**Application Reference:** 2024/0689

**Site Address:** 12 Lakeland Close, Cudworth, Barnsley, S72 8SL

This application seeks planning permission for the erection of single storey outbuilding to rear, and detached garage to side of 2 storey detached dwelling

DRAWING TITLE  
Outbuilding Combined Plans

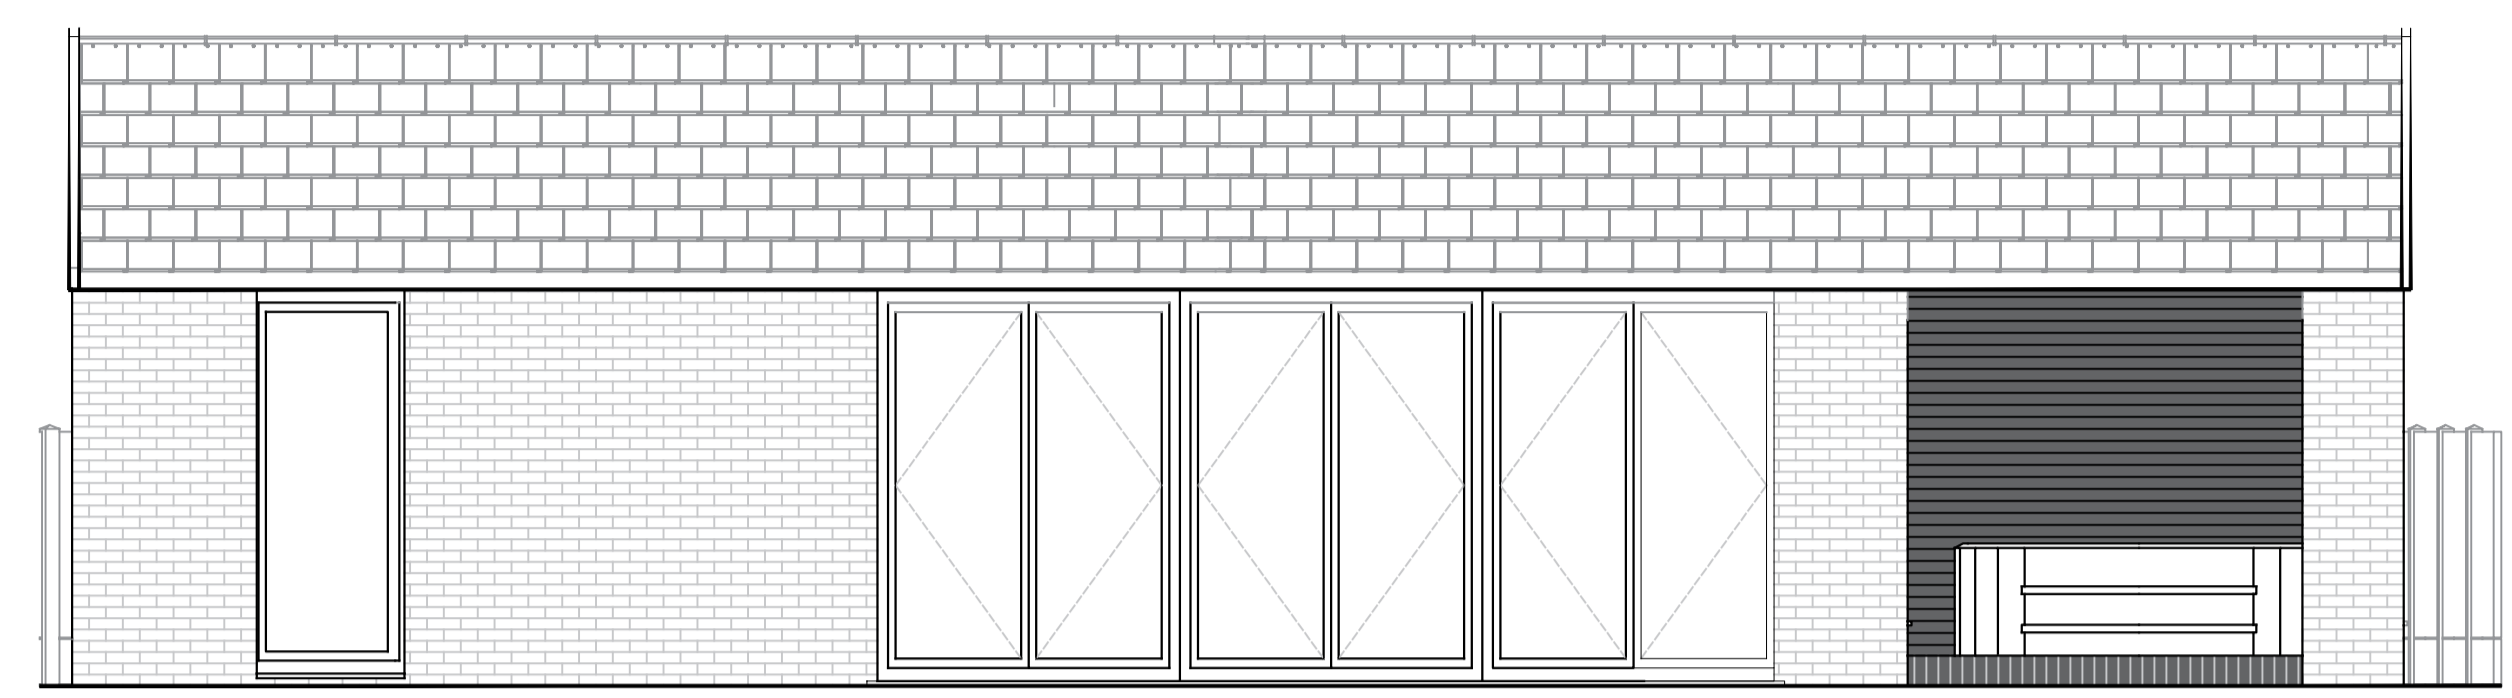
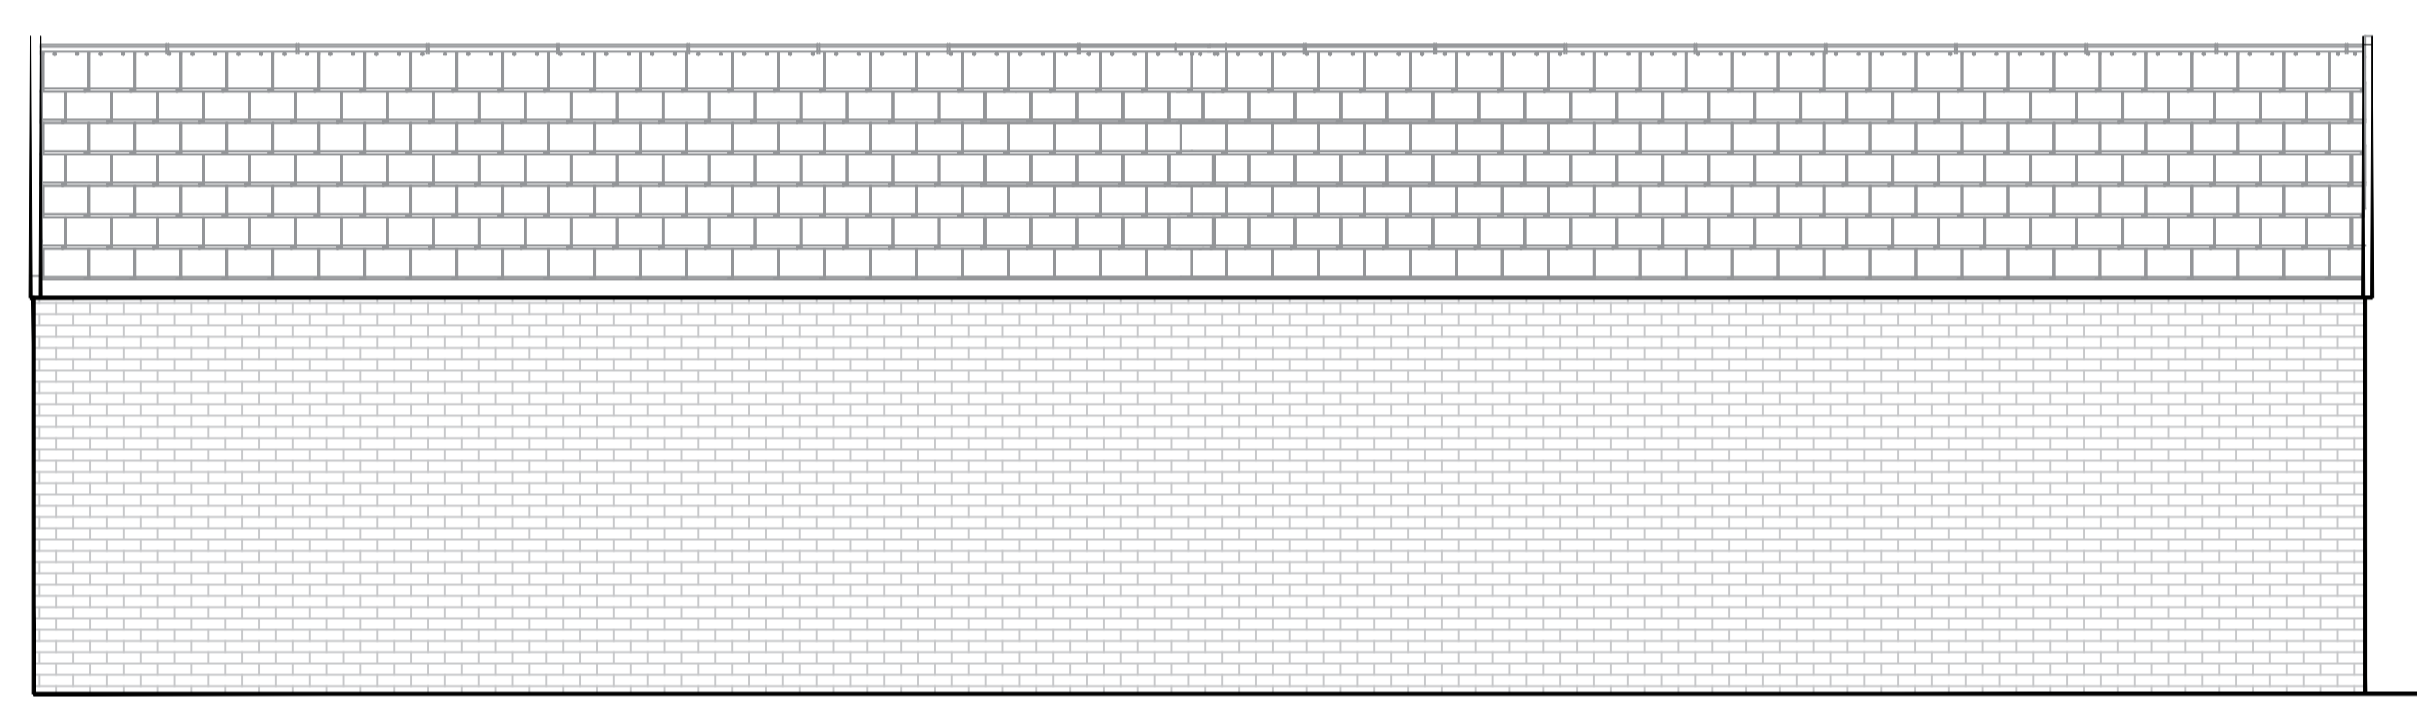
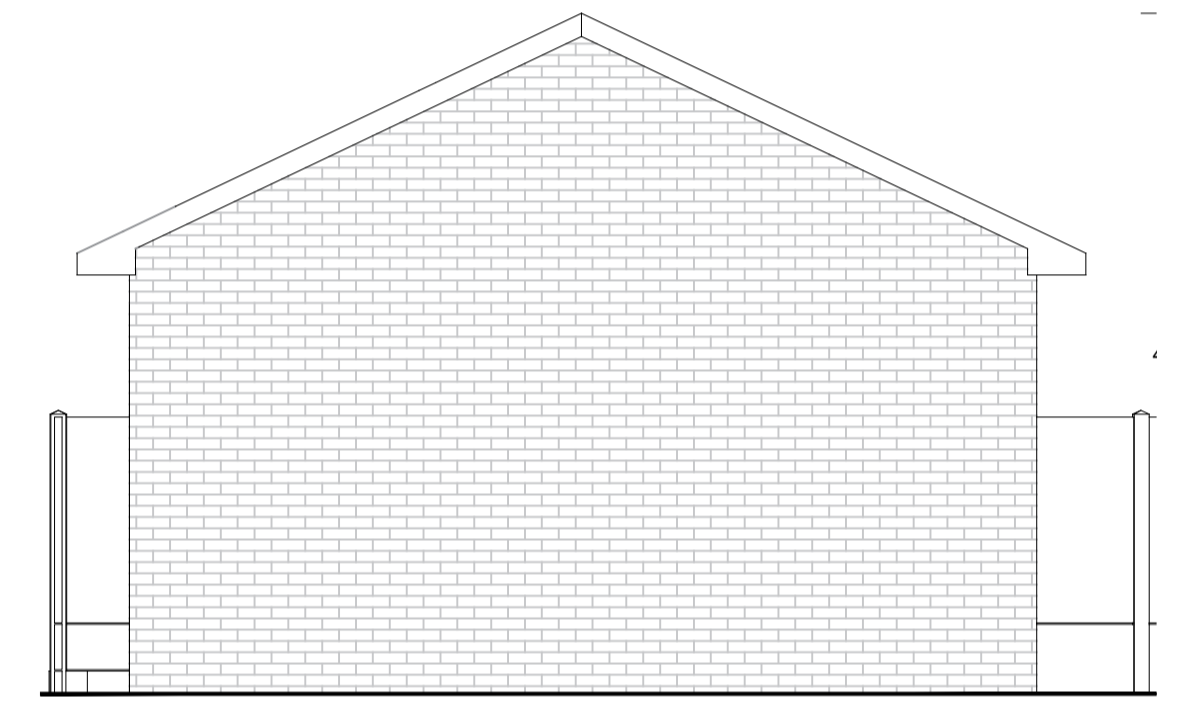
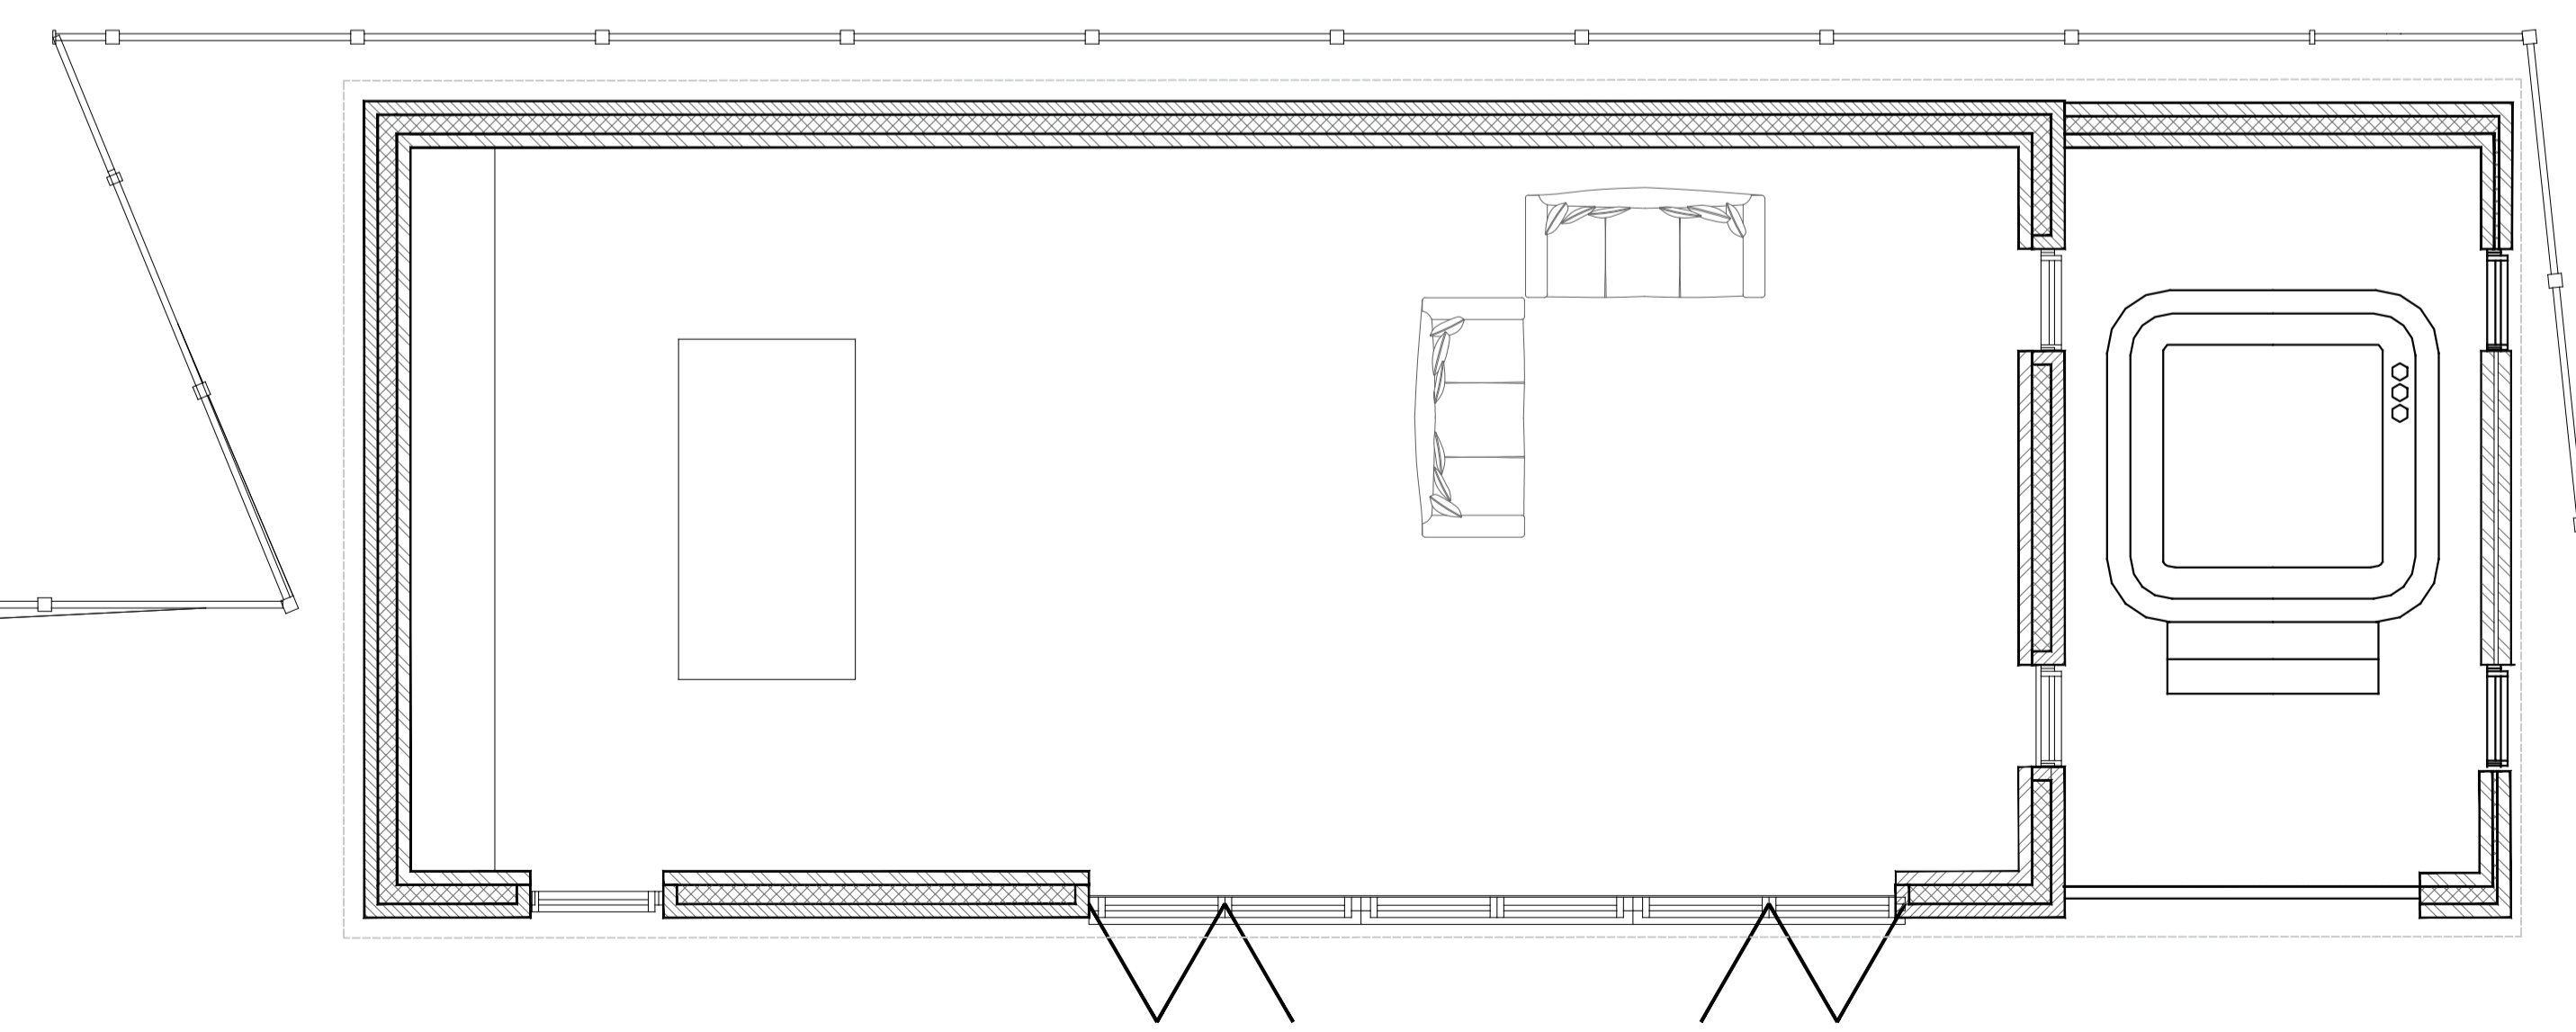
The second part of the proposal is for a detached outbuilding, in replacement of an existing smaller outbuilding, located in the rear garden, adjacent to the western boundary with a neighbouring rear garden, and a small area of southern boundary with a different neighbouring rear garden. Similarly to the garage, the proposed outbuilding has been reduced in scale and would also be constructed of brick and feature a tiled, dual pitched roof. The approximate length of the proposal running along the western boundary would be approximately 15.42m, whilst the proposed width would be 6m. Due to possible differences in ground level, the eaves vary in height between 2.35m and 2.5m high, but the roof remains at a constant height of 4m. Internally the proposal would feature two sections, the first, a kitchen and entertaining space,

and a separate room, more akin to a storage area, for the installation with a hot tub. The front elevation overlooking the garden would feature full height window and a separate Bi-fold glazed doors, but the section including the hot tub would feature roller shutters or similar.

In mitigation of the outbuilding's size is its location and subservience to the main dwelling. It is out of view of the street scene and would take up less than 20% of the rear garden area leaving a large private amenity space remaining. Given the two storey nature of the existing dwelling the size of the outbuilding would remain subservient to the main property and, if located approximately 1m further away from the boundary, would be classed as permitted development. The materials and design are in keeping with the existing property so it would not appear as a prominent or discordant feature, Whilst it's size is not in line with the SPD, in this instance the circumstances of the site mean the large size does not cause any significant detriment to the site or its surroundings to warrant refusal of the application. However, a condition is recommended so it remains ancillary to the main dwelling.

With the proposed outbuilding being of a size allowable through permitted development, the only thing preventing the application being constructed through this method is its location within 2m of the boundary treatment. With a high hedgerow separating the proposed outbuilding from the neighbouring garden, and an approximate 1m distance from the rear boundary treatments, it would seem unreasonable to request the proposal was removed 1m further into the garden when it would have no positive impact on the amenity of the neighbouring dwellings. Moreover, whilst the proposal is larger than the existing outbuilding, the existing outbuilding is situated directly adjacent to the boundary. With the proposed used of the outbuilding for entertainment and leisure purposes, whilst there may be some additional noise created, it would not be expected to be above anything experienced by other leisure activities undertaken within a garden. In consideration of all aspects, the proposal would be expected to have no more than a limited impact on the neighbouring amenity of neighbouring dwellings.
